Appeal Decision

Appeal Ref: APP/R4408/W/19/3222977

12-14 Eldon Street North, Barnsley S71 1LG

- The appeal is made under section 78 of the Town and Country Planning Act 1990 against a refusal to grant planning permission.
 - The appeal is made by Mr D Appleby against the decision of Barnsley Metropolitan Borough Council.
 - The application Ref 2018/0946, dated 24 July 2018, was refused by notice dated 20 September 2018.
 - The development proposed is a change of use from A1/B1 to Sui Generis Proposed 8 Bedroom House of Multiple Occupation.
-

Proposed Elevations

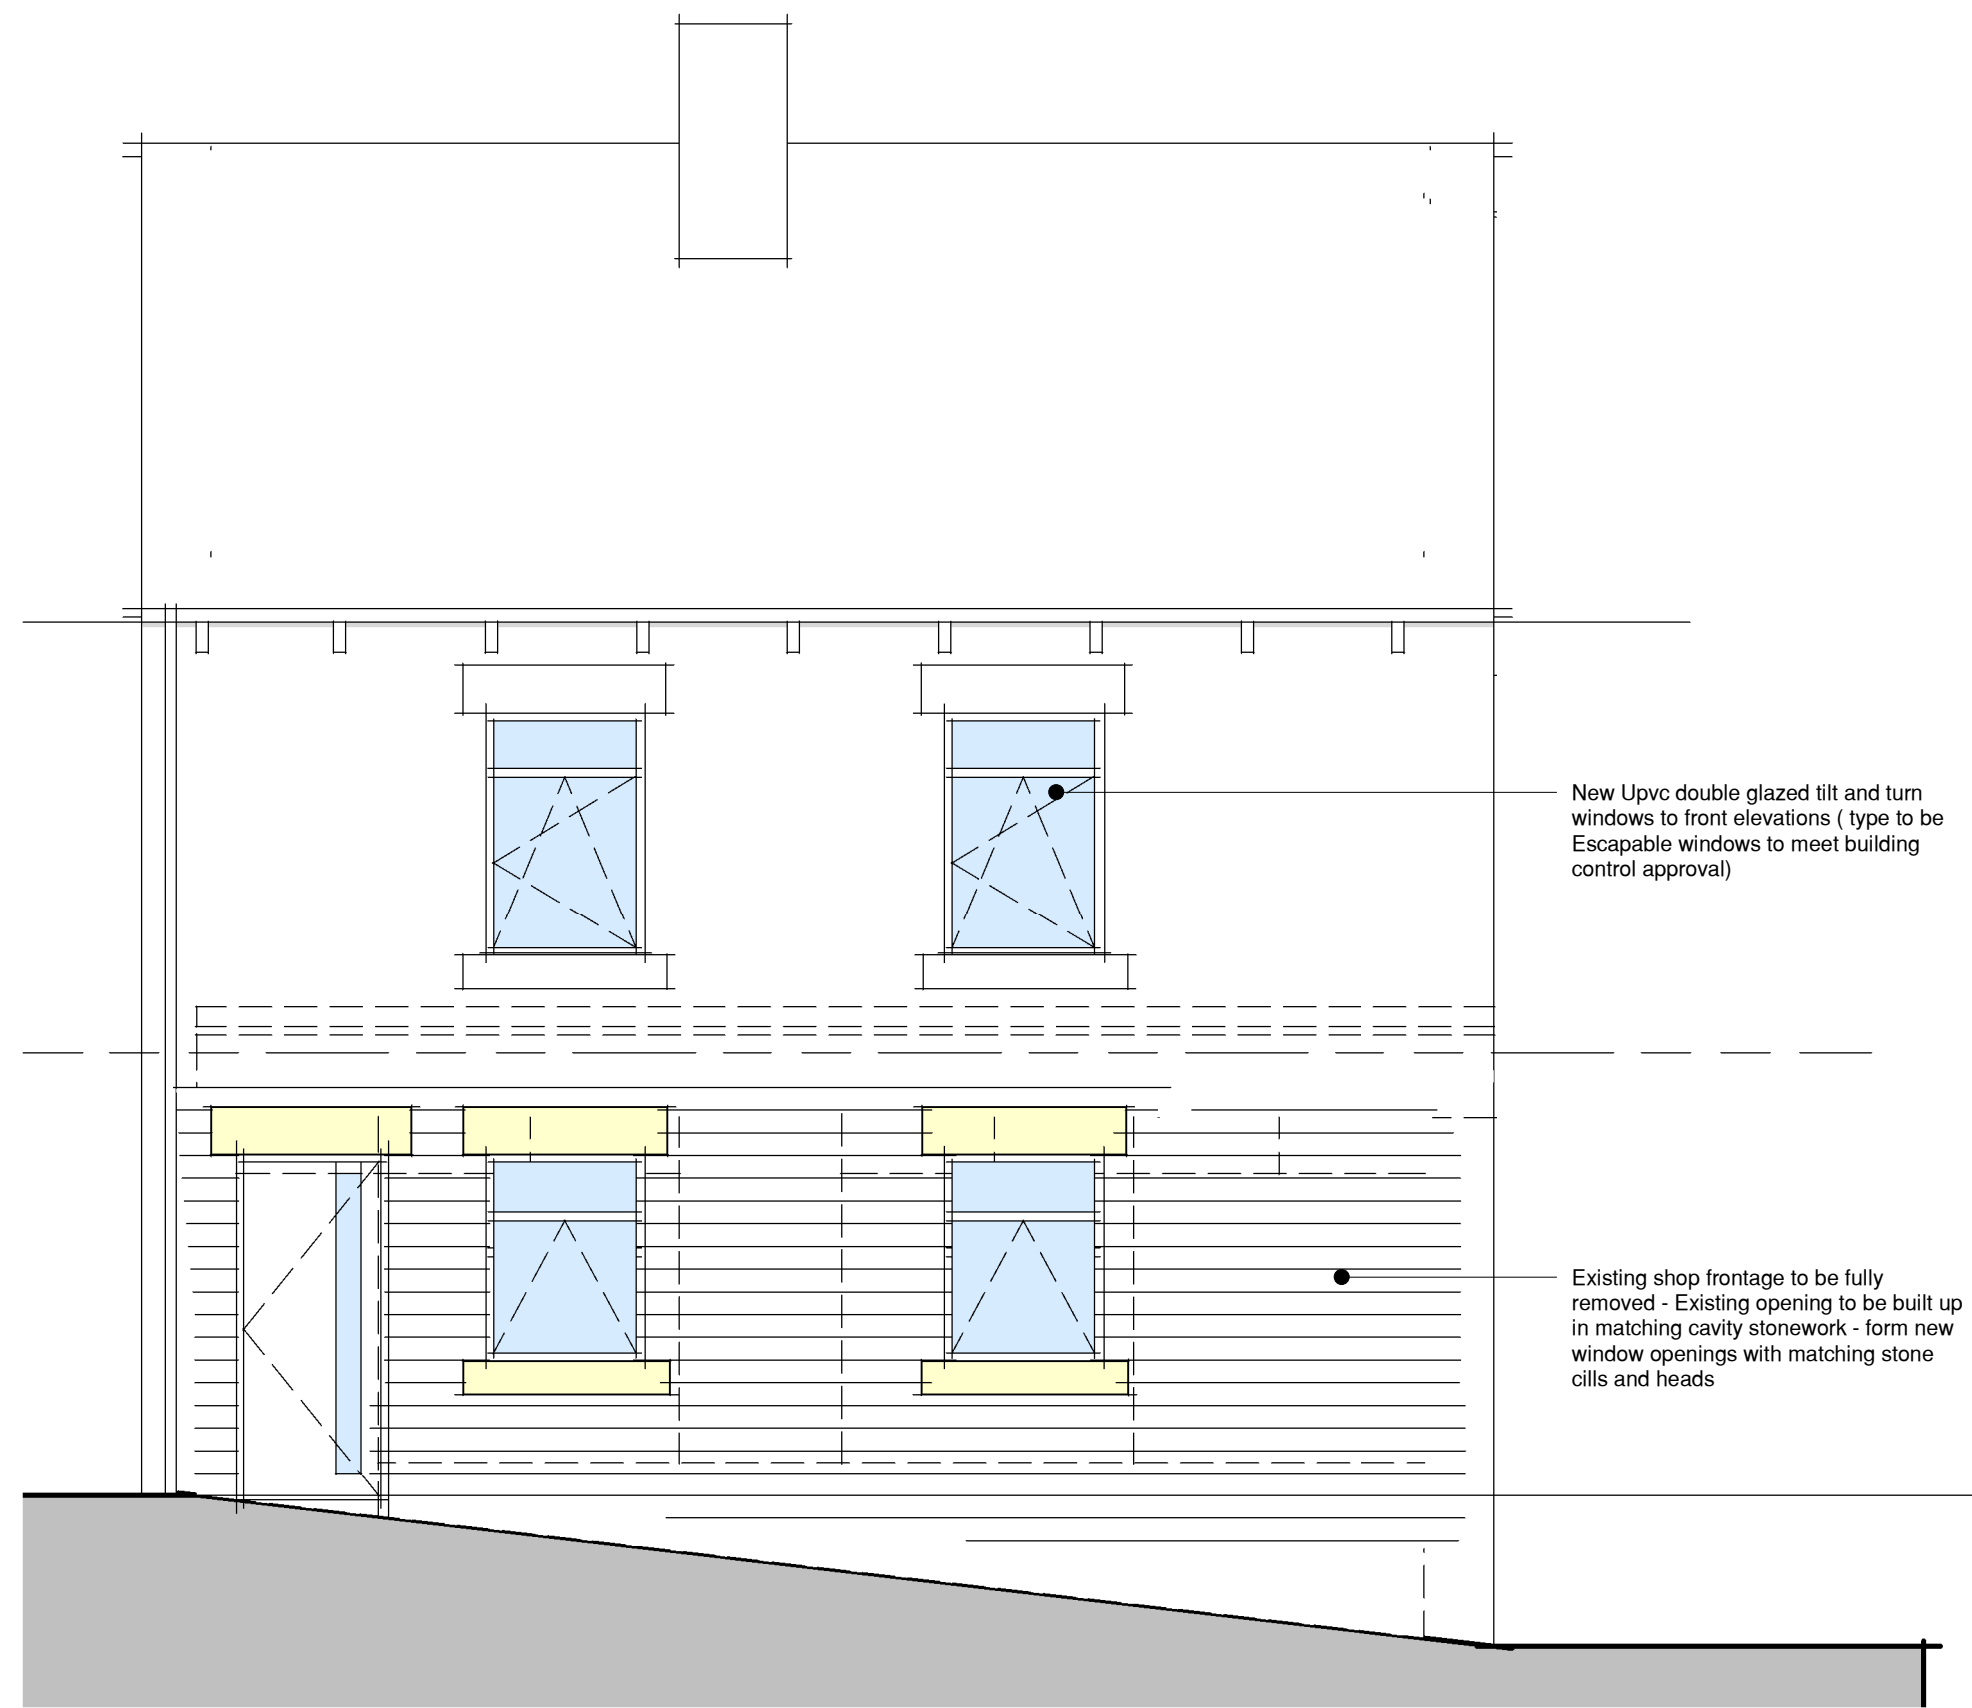
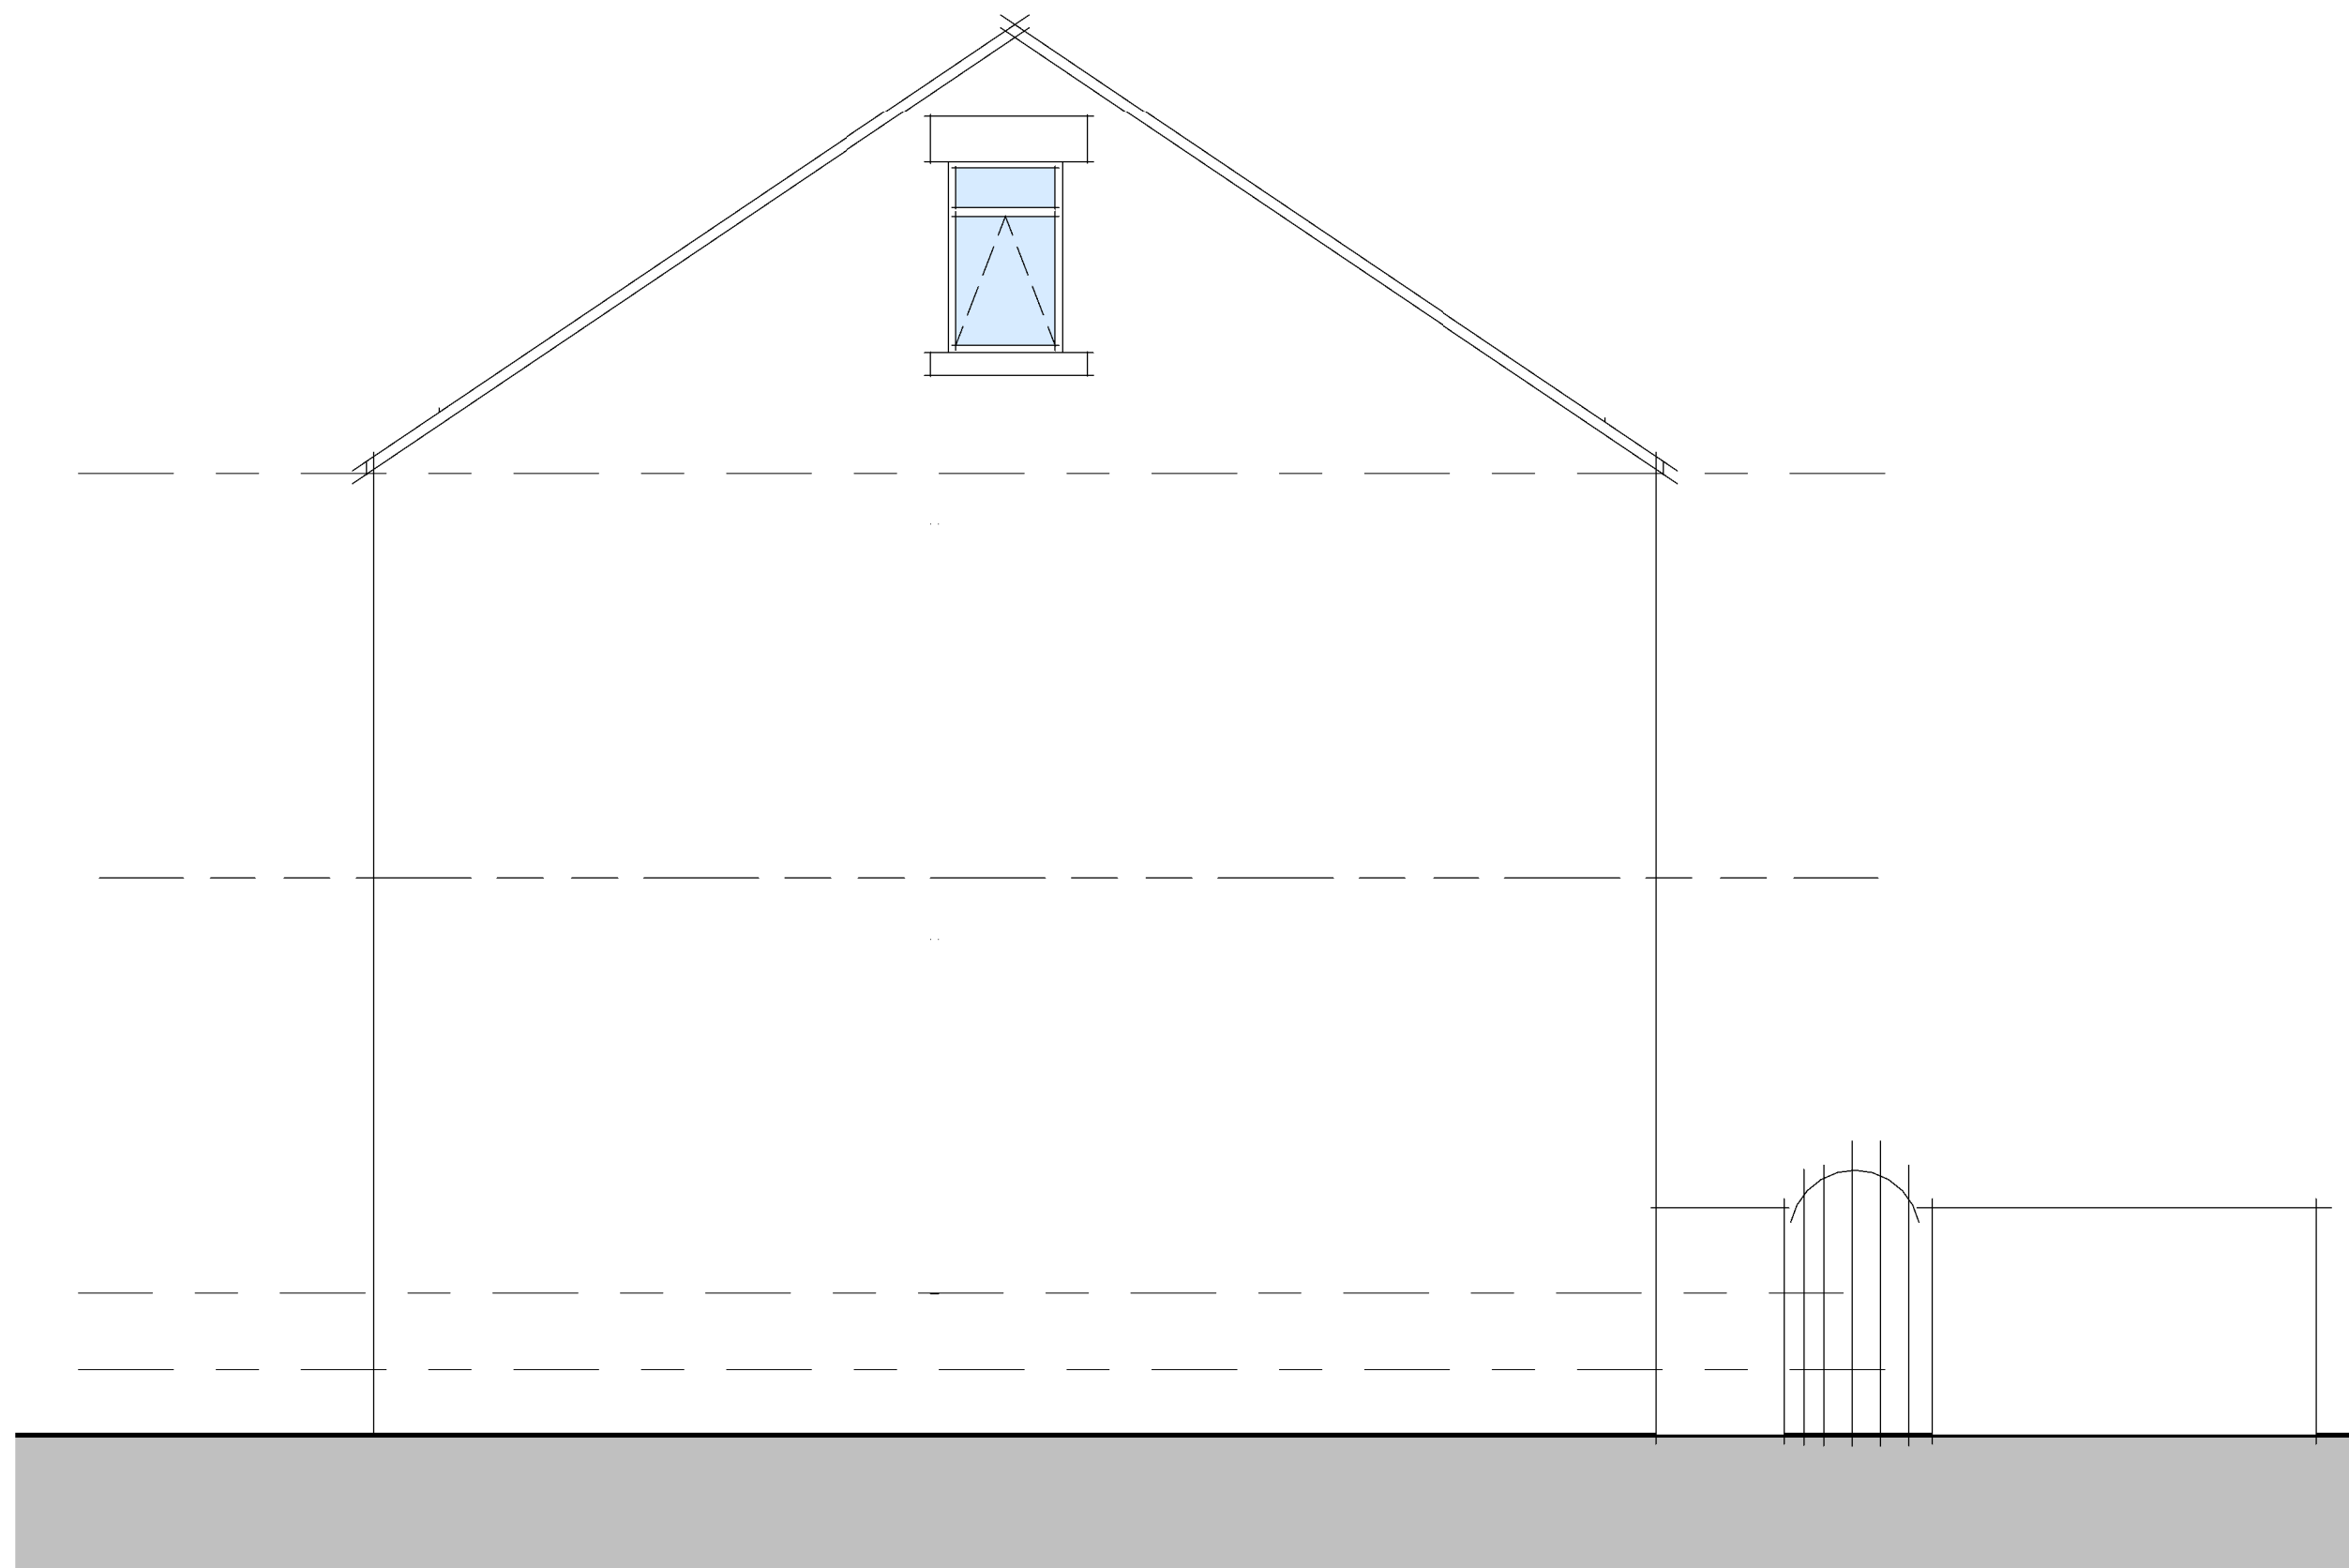
15. In this case, the rear boundary would be 6m away, below the guidance within the SYRDG. However, it is an existing relationship as a consequence of historic development. Moreover, the first-floor windows of the appeal property principally face towards the flank elevation of the dwelling at 2 Bridge Street with only an oblique view to the garden of this property. For this reason, even if the HMO would result in an increase in activity compared to a family dwelling, I consider that there would be no harmful effect to the living conditions of neighbouring occupiers in respect of overlooking.
